14 April 2021

David Schwebel
Planning Officer, Industry Assessments
Department of Planning, Industry and Environment
Via email: david.schwebel@planning.nsw.gov.au

Advisory comments on the Response to Submissions - State Significant Development Application - 200 Aldington Road Industrial Estate (SSD-10479)

Figure 5 Proposed Concept Plan

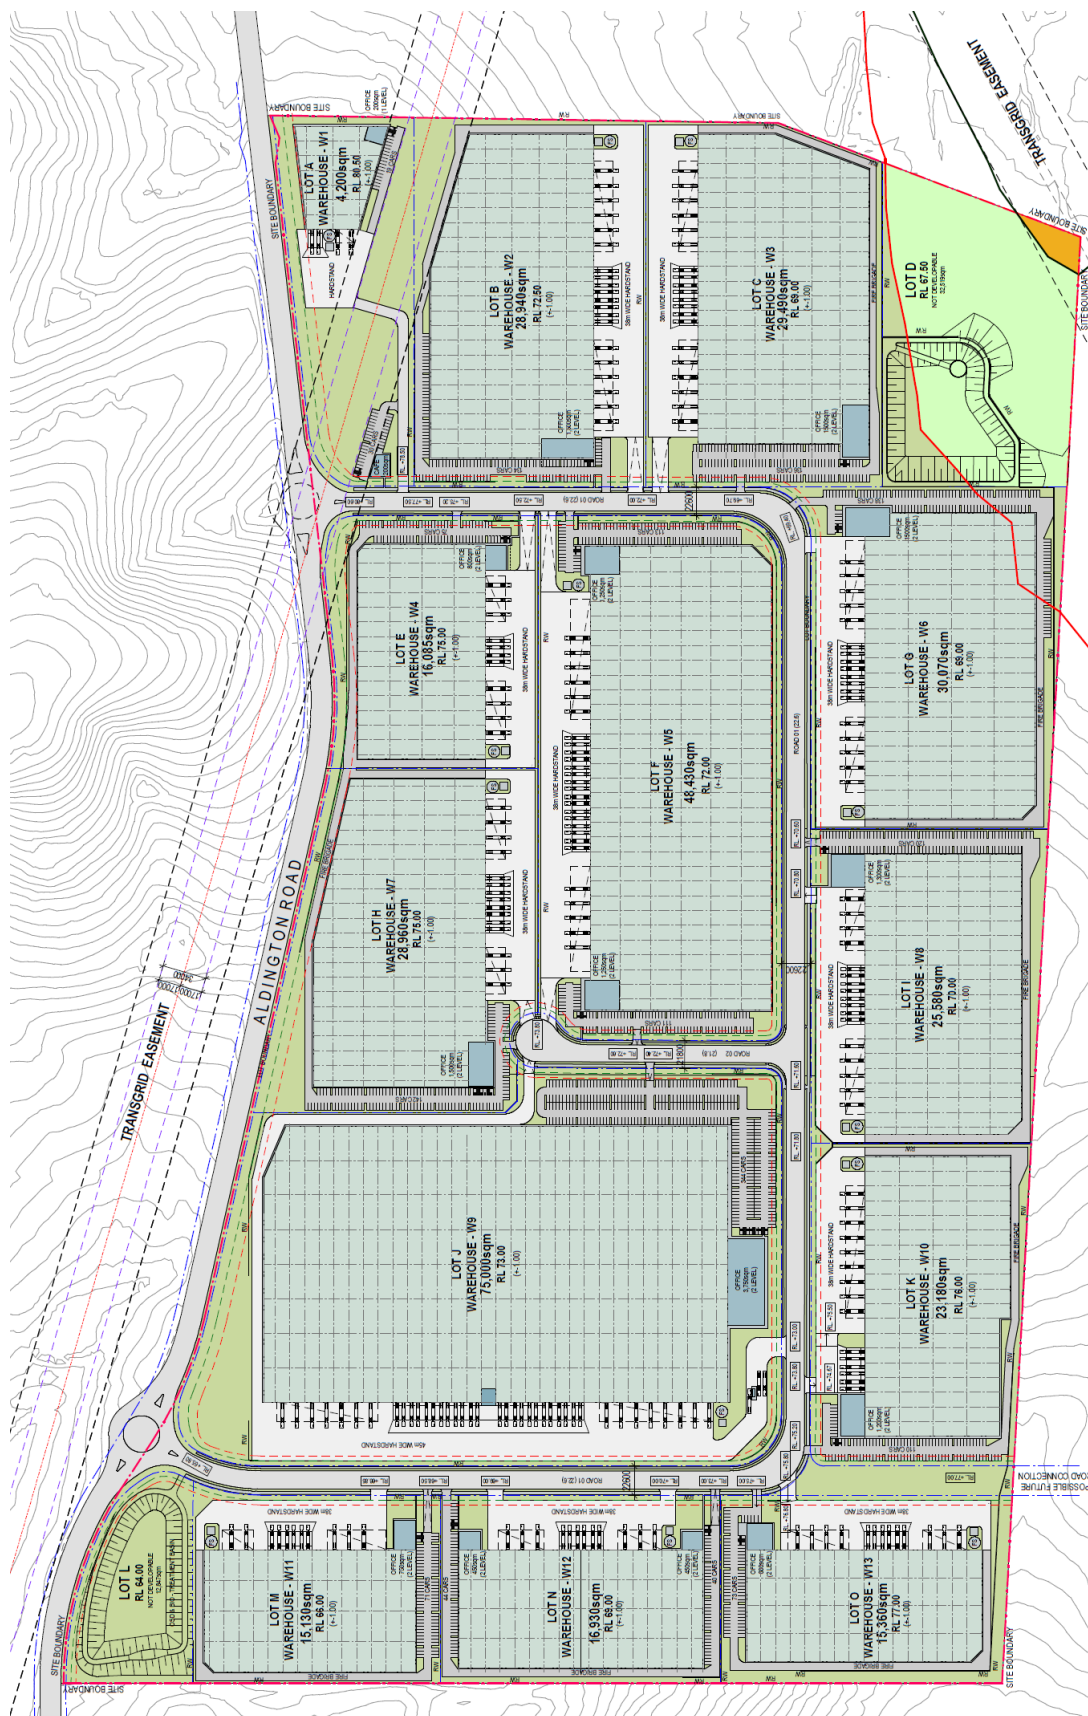
Generally, the proposed development appears to be consistent with these. However, the Partnership remains concerned about the placement of the building footprints and parking areas partly within the 1:100 flood area under the revised concept masterplan and the impact such development will have on flood waters.

In addition, the Partnership is also concerned about the building footprint of Lot G and associated parking which is partly within land zoned RE2 Private Recreation (Figure 1). It is recommended that the building footprints be wholly contained within the IN1 General Industrial zone and above the 1:100-year flood prone land. If approved as per the current proposed application, it could set an undesirable precedent across the Aerotropolis that would be inconsistent with the strategic planning objectives of the WSAP.

Guidelines. The changes to the plans such as the relocation of the first order watercourse may improve riparian outcomes but do not adequately address the development of warehouses within the RE2 zone, which is a prohibited use in the zone.
